**WELWYN HATFIELD BOROUGH COUNCIL
ASSISTANT DIRECTOR (PLANNING)**

DELEGATED APPLICATION

Application No: 6/2023/0874/HOUSE
Location: 11 Thistle Drive Hatfield AL10 9FQ
Proposal: Erection of single storey rear extension with flat roof and skylight
Officer: Mrs Kerrie Charles

3584-22A3-01

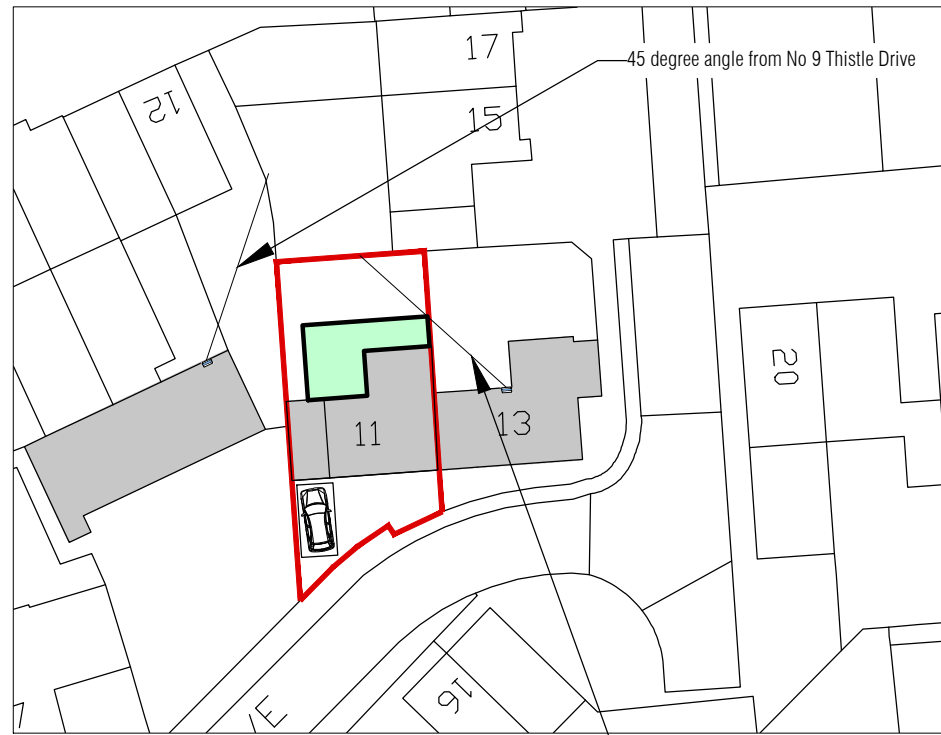
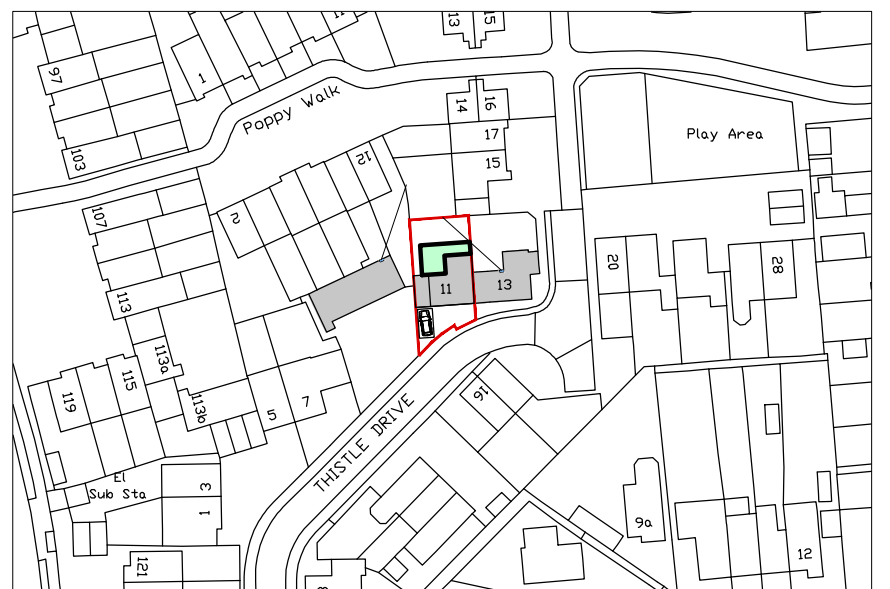
The development would result in the loss of one parking space in the rear garden.

The Council's parking guidance SPG recommends that in this area 2.25 spaces are provided for a three bedroom dwelling. The existing carport will be retained, which falls short of the standards in the Interim policy, which states that for new domestic garages to have a genuine ability to be used for their intended purpose, they should be at least six metres long by three metres wide and sufficiently tall to accommodate modern cars. However, the also site benefits from a section of hardstanding which can accommodate parking.

DRAWING NO:
3584-22A3-03

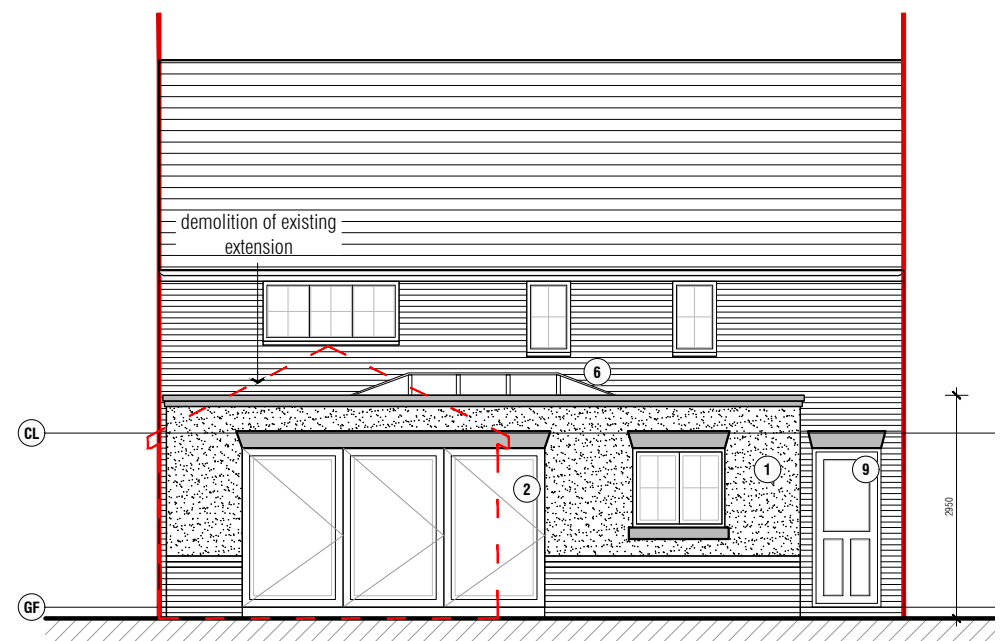
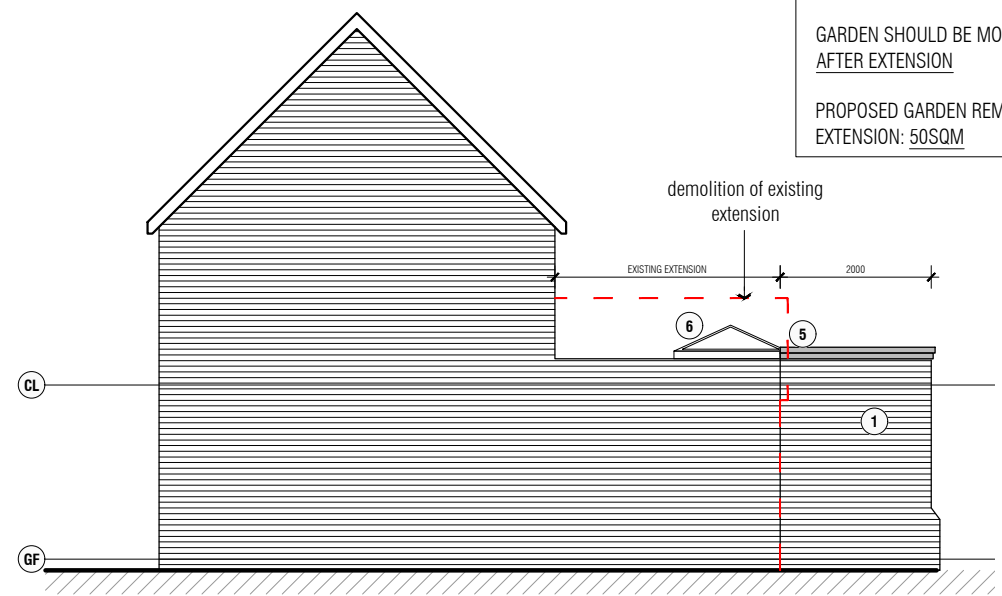
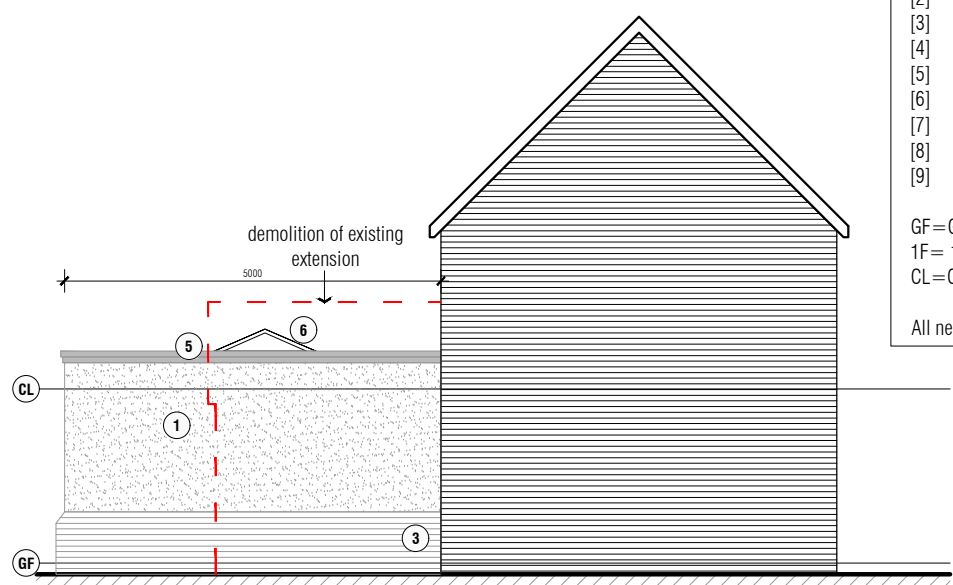
The proposed extension would be located to the rear of the host dwelling and would replace part of the rear elevation which extends by 3m. The development would not be visible from the street, however, it would be visible from neighbouring properties.

The proposed materials are to match the existing dwelling. As such, the extension would not result in an unduly prominent feature and would maintain the character of the area.

Although the extension would have a total depth of 5m along the shared boundary, the carport at No.13 Thistle Drive provides an adequate separation distance and the extension would only extend a further 2m than the existing extension, therefore the extension would not have any determinantal impact on any ground floor window.
